The Secretary
NSW Department of Planning, Industry and Environment

23 August 2020

I refer to the Department's below email of 14 August 2020 regarding the Environmental Impact Statement (EIS) for State Significant Development SSD-10477 Sydney Business Park - Stage 3 for construction and operation of Stage 3 of Sydney Business Park. Comprising of four Warehouse and Distribution Centres, roads and infrastructure located at Hollinsworth Road and Astoria Street, Marsden Park (Part Lots 4 and 5 DP 1210172 and Part Lot 36 DP 262886) in the Blacktown City LGA. Submissions need to be made to the Department by 17 September 2020.

Figure 1: Site Plan

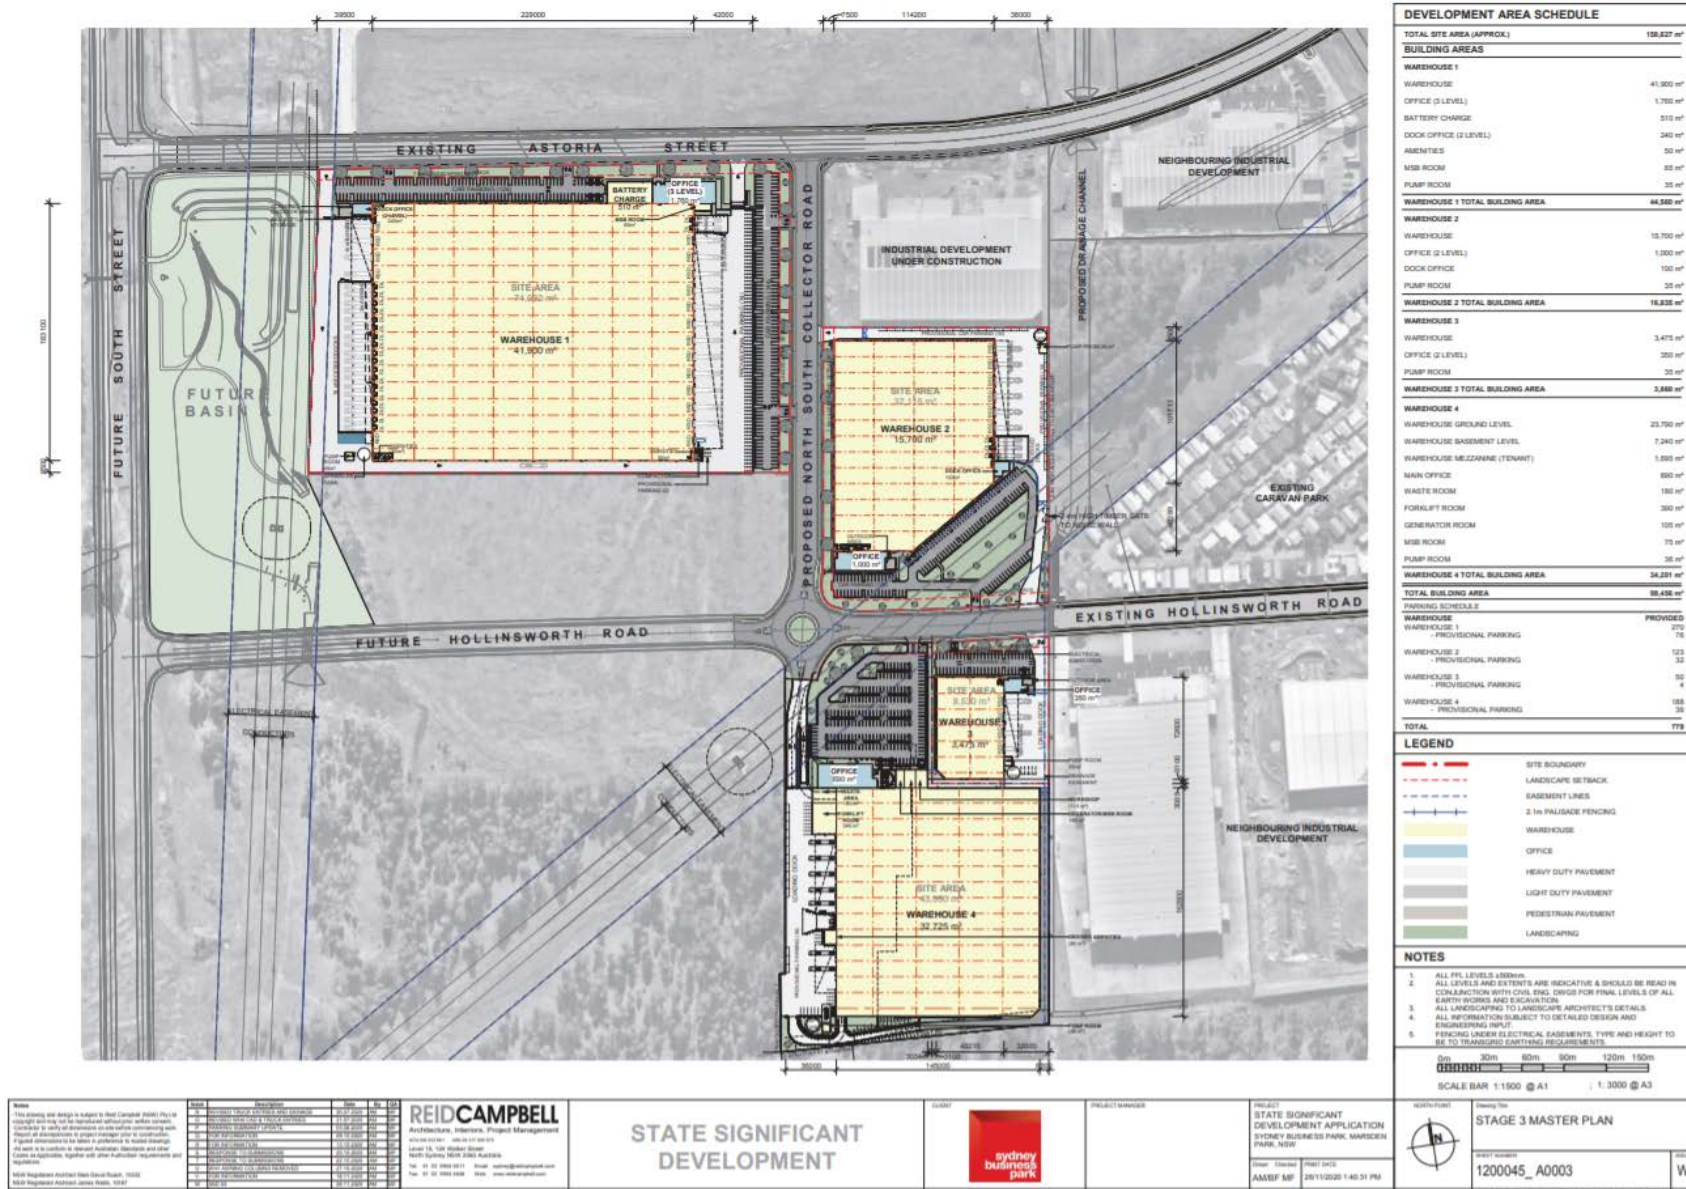
Endeavour Energy has also noted that as shown in the following extract of the WH4 – Site Plan that provision has been made for two padmount substations. From Endeavour Energy's perspective the fact that provision is being made for the substation is a positive Endeavour Energy's general requirements is for a padmount substation be at ground level and have direct access from a public street unless it is provided with a suitable right of access and with an easement for the associated underground cables.

In regard to the proximity of the 'Diesel Generator Refueling Place' to the padmount substations, Endeavour Energy is aware that the provisions of State Environmental Planning Policy No 33— Hazardous and Offensive Development (SEPP33) in the preparation of a preliminary hazard assessment electricity infrastructure is not defined / regarded as sensitive land use. However, in similar situations Endeavour Energy has sought further advice from the consultants preparing the preliminary hazard assessment on the basis that, although not a sensitive land use in the traditional / environmental sense, if the electricity infrastructure on or in proximity of the site (which also may be a potential ignition source) is damaged, the resulting outage could leave many properties / customers without power. The consultants have been requested to specifically address the risks associated with the proximity of the electricity infrastructure ie. detail design considerations, technical or operational controls etc. to demonstrate as required by SEPP33 that the proposed business / development is suitably located and can be built and operated with an adequate level of safety and pollution control. Endeavour Energy's recommendation is that the separation distance be increased to as far as reasonably possible to minimise any potential risk.
